From: Amanda Scholes on behalf of Planning.Responses
Sent: 22 August 2019 10:49
To: Planning Scanning
Subject: FW: Lu/194/19/doc : 22 Beach Road, Littlehampton. Application for Discharge of Planning Condition 4

From: Carol Reynolds
Sent: 21 August 2019 08:15
To: Planning.Responses <[REDACTED]>
Cc: Anita Gardner <[REDACTED]>; Juan Baeza <[REDACTED]>; Tracey Headley-Smith <[REDACTED]>
Subject: FW: Lu/321/17/PL - 22 Beach Road, Littlehampton. Application for Discharge of Planning Condition 4

Environmental Health: With reference to that document provided by Acoustic Associates, Project Number J2707, Issue One, BS 8233:2014 Assessment. This assessment would only appear to consider road noise and noise from the mechanical ventilation system to Pizza Hut. Emphasis is placed upon the fact that the food business will operate between 12:00 and 23:00 hours, with switch off of the ventilation system at 23:00 hours. The fact that the condenser unit to the walk-in chiller is positioned almost, if not immediately beneath habitable rooms to Flat One does not appear to have been included, despite the fact that this is likely to run and to cut on and off throughout any night. The report also seems

Figure 7. Review of 1-hour periods inside Flat 1 bedroom

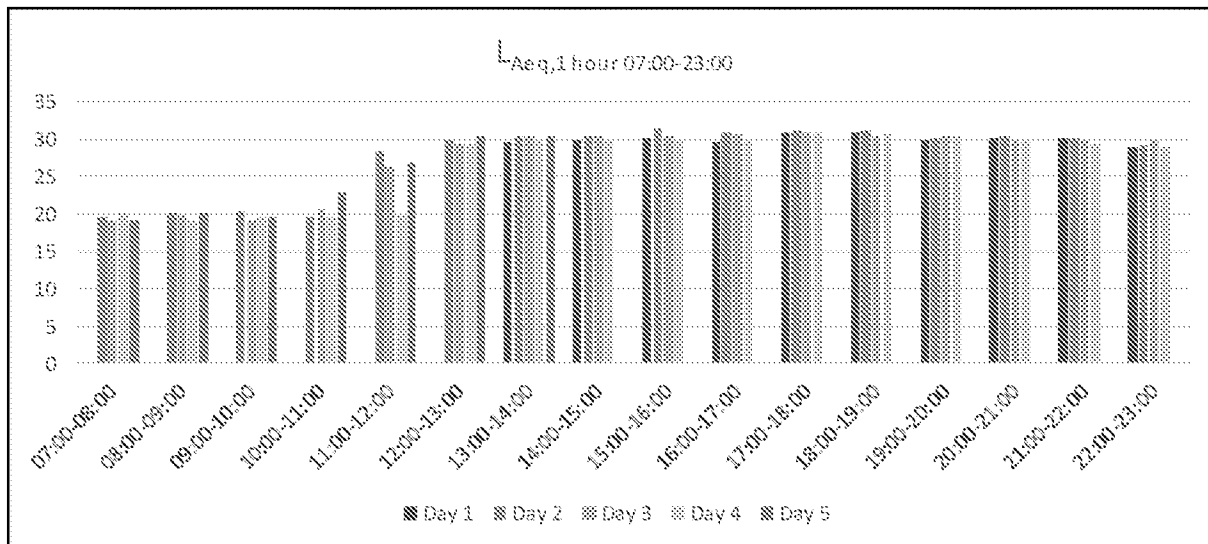
Flat 1: The report makes certain assumptions in respect of sound absorbtion once the premises is furnished. However, it also clearly states that a laminate floor will be provided meaning that sound absorbtion from soft furnishings is likely to be minimal. Average day time measurements (Figs 6 & 7, page 10) show a 'best case' scenario, indicating that with windows open (rather than closed as during the assessment period) a level of 39 to 44 dB could be expected meaning that windows would need to be kept closed if they were to comply with BS8233 guidance. Although, night time levels would appear to be acceptable, as stated intermittent condenser noise must be factored in to this calculation.
